From: Contact Centre (CRM) <contact@ribblevalley.gov.uk>
Sent: 23 January 2026 17:25
To: Planning
Subject: Planning Application Comments - 3/2025/0987 FS-Case-789825924

Planning Application Reference No.: 3/2025/0987

Address of Development: 4 West View
Grindleton
Clitheroe
BB7 4RB

Proposed Ground Floor Plan

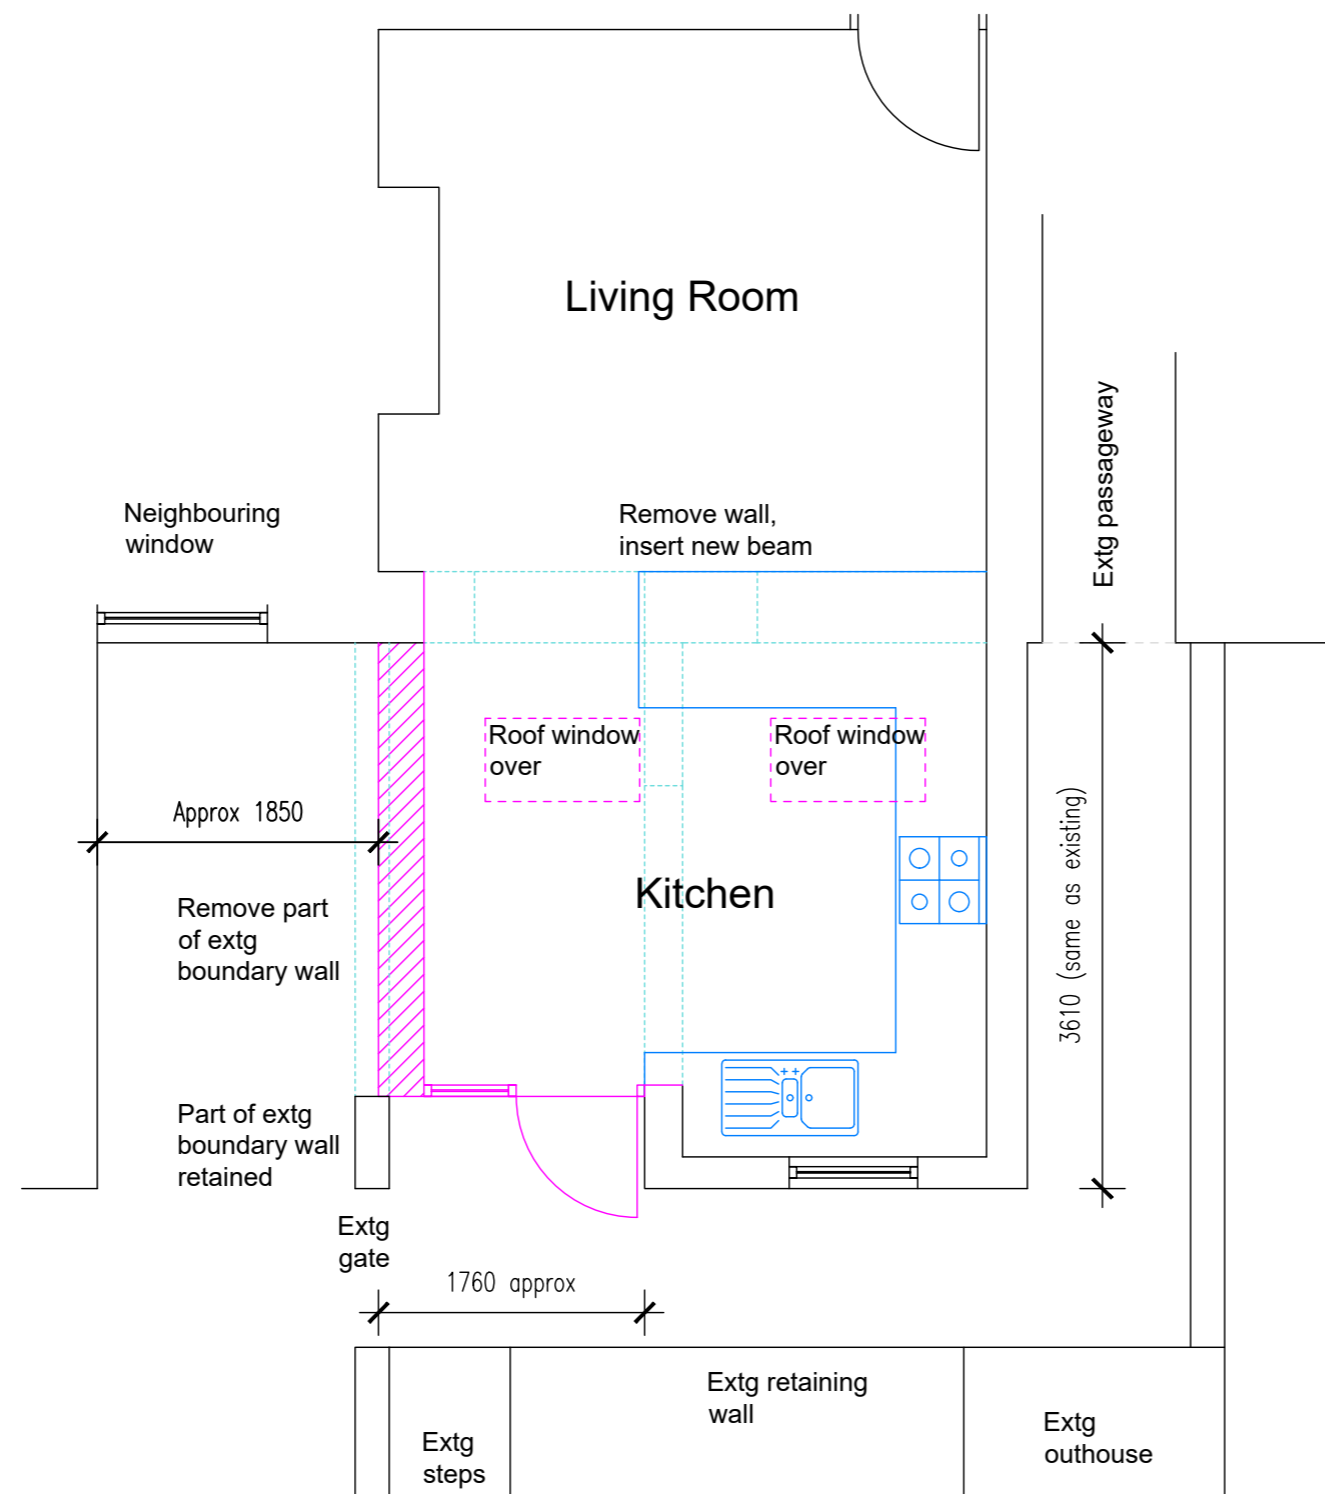
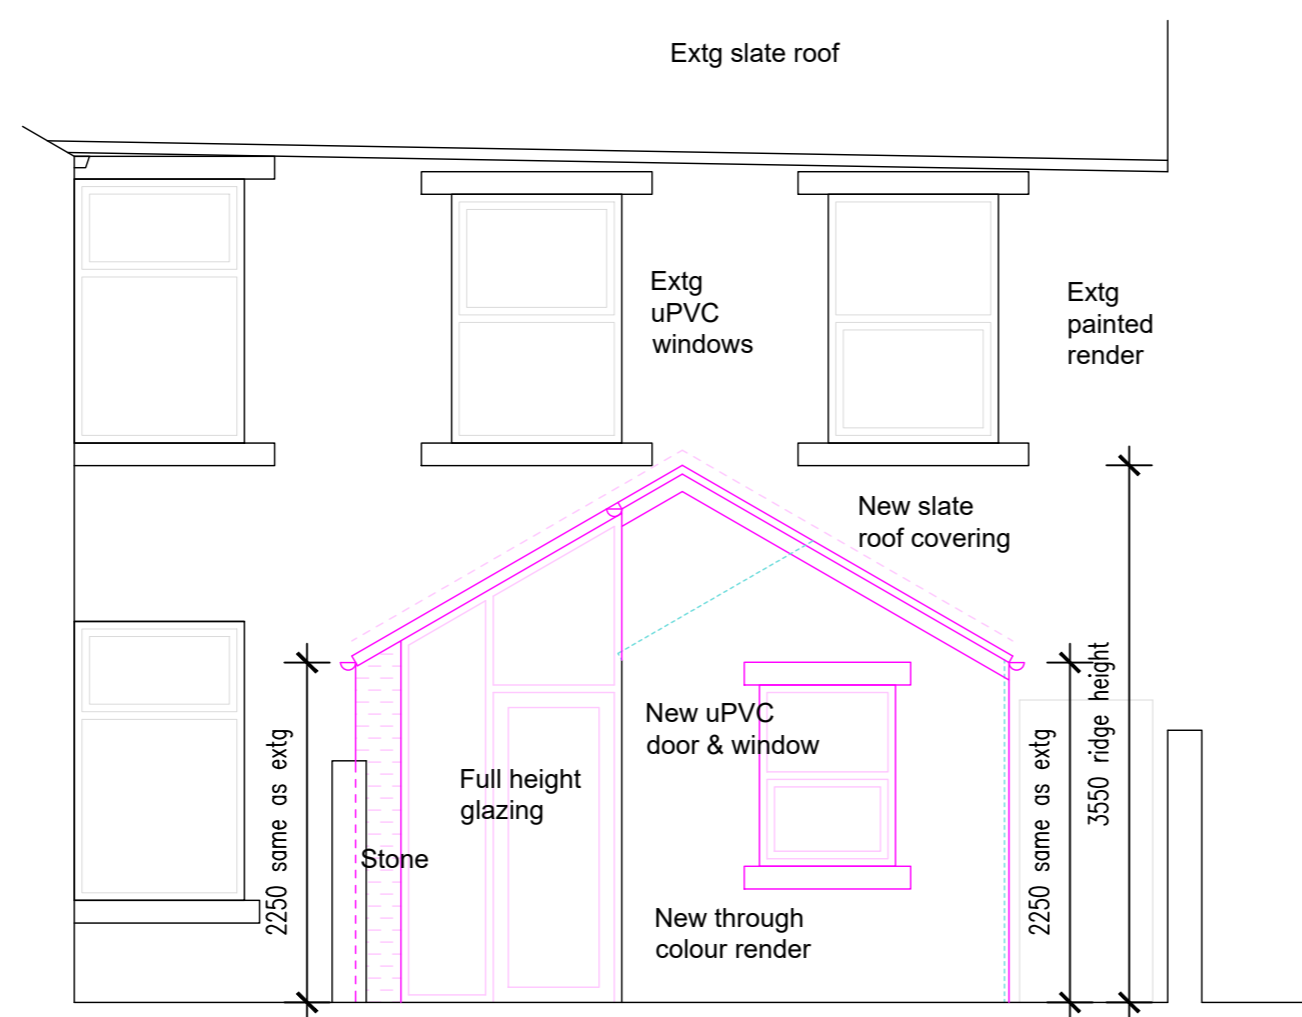
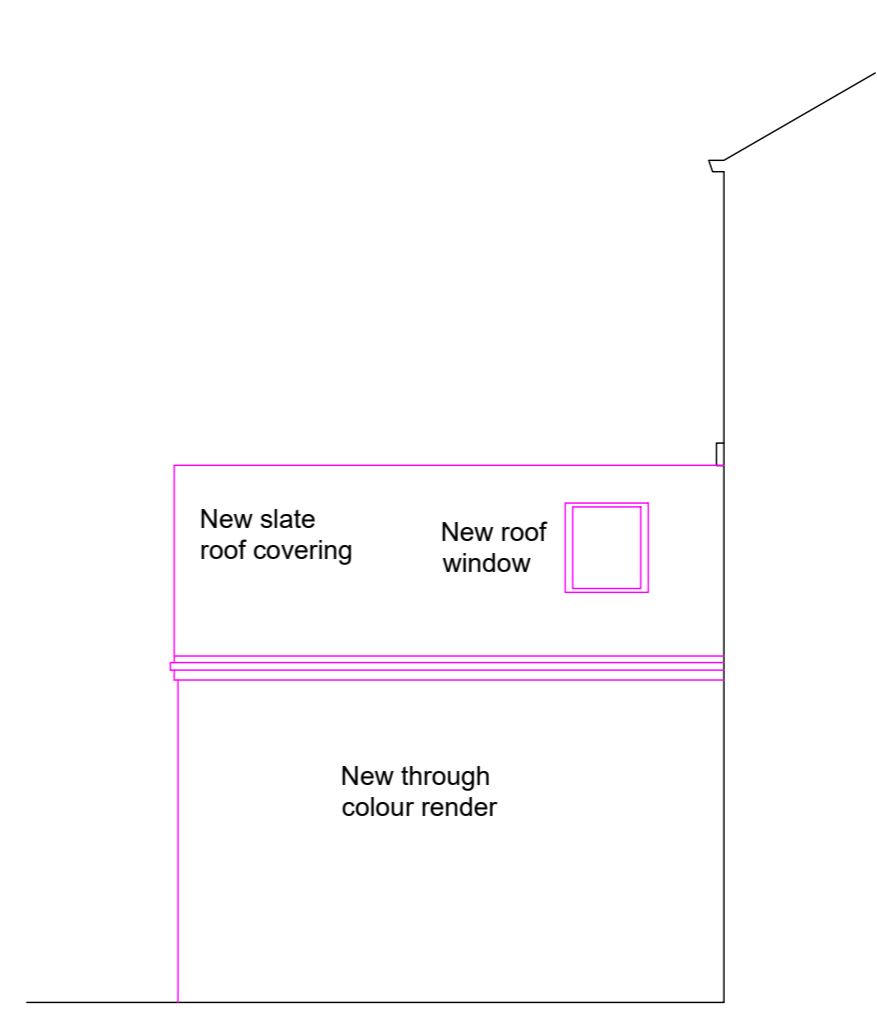
Comments: I have no objections to the revised plans, and I fully support Mr Evans extending his house to make a bigger kitchen. My only stipulation is that the boundary wall is rebuilt as is and that the wall of the extension does not go beyond the boundary line.
There will be no impact for me as the direction of the sun is opposite the extension, not behind, and so there will be no reduction in light.
Thank you
